RE: PPR262 Security Water District IXWTP Building Addition

This transmittal letter has been prepared to demonstrate the responses to the comments from your June 17, 2026, review.

**SWD PROPERTY SITE PLAN
WATER TREATMENT PLANT BUILDING ADDITION
SECURITY WATER DISTRICT**

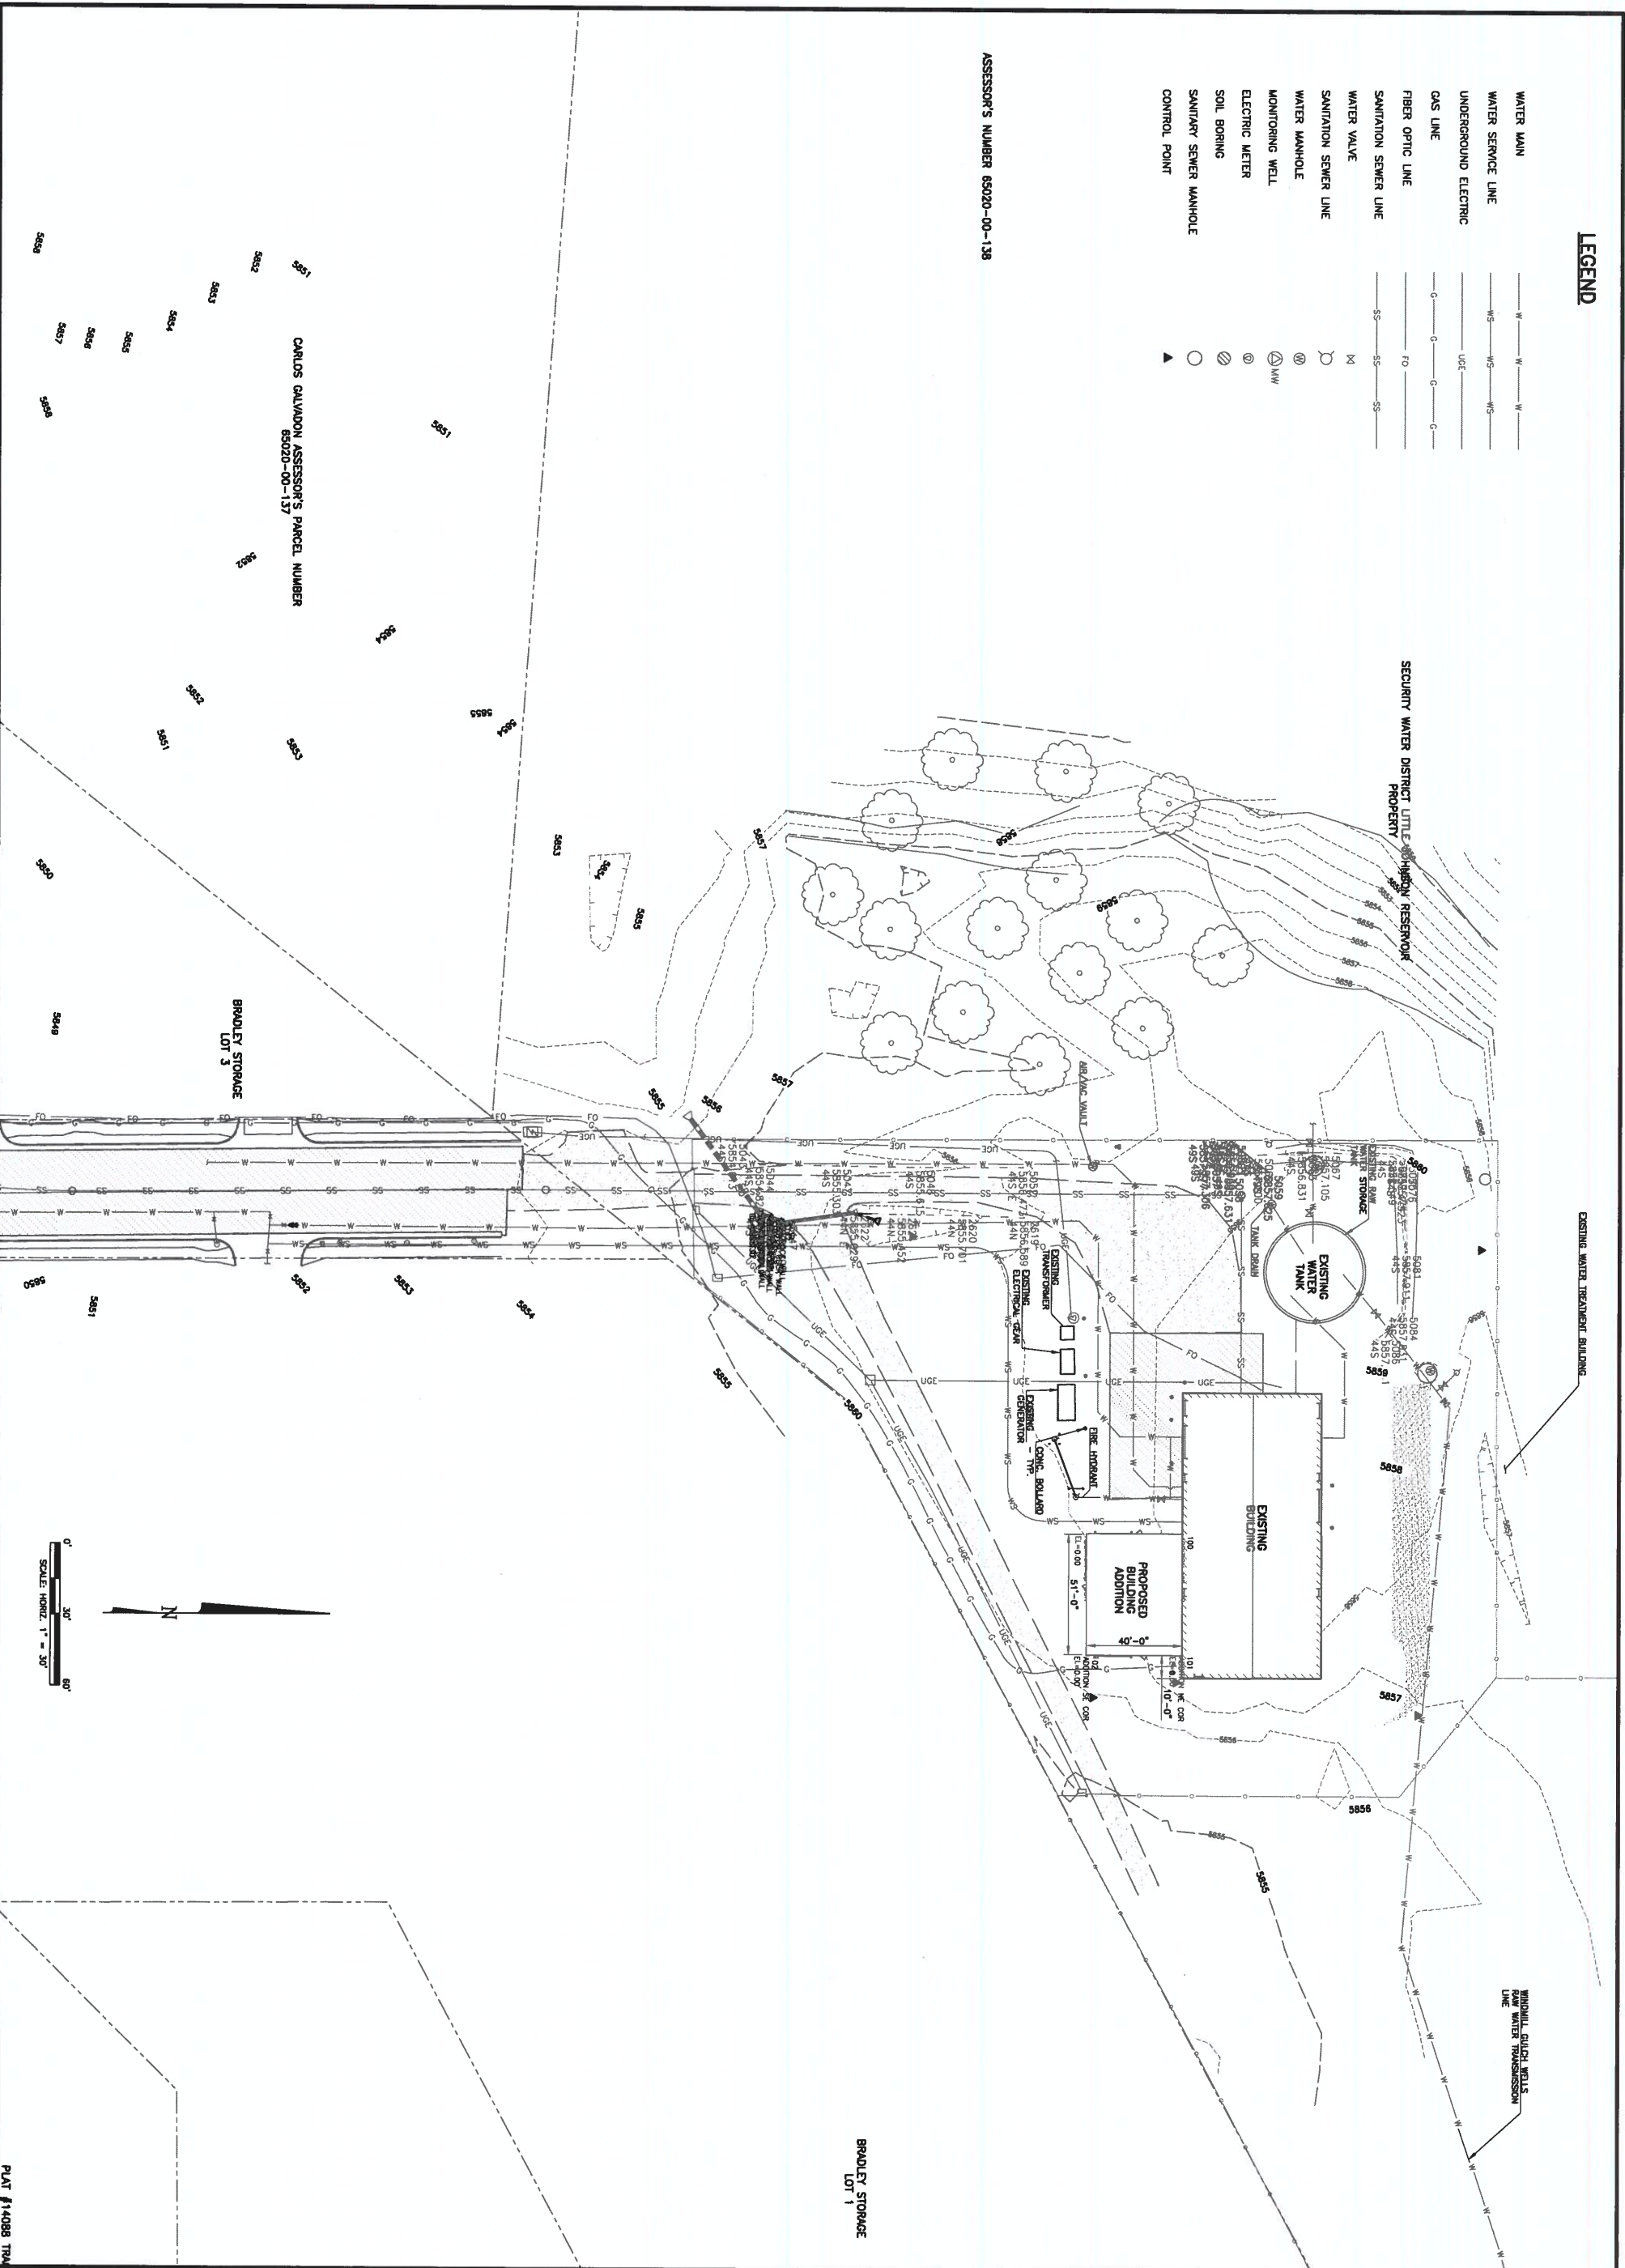
- Sheet 3 –
 - Please show all drainage improvements on the site development plan.
GMS Response: Sheet 3 now shows the updated SWD Pond No. 1 improvements.
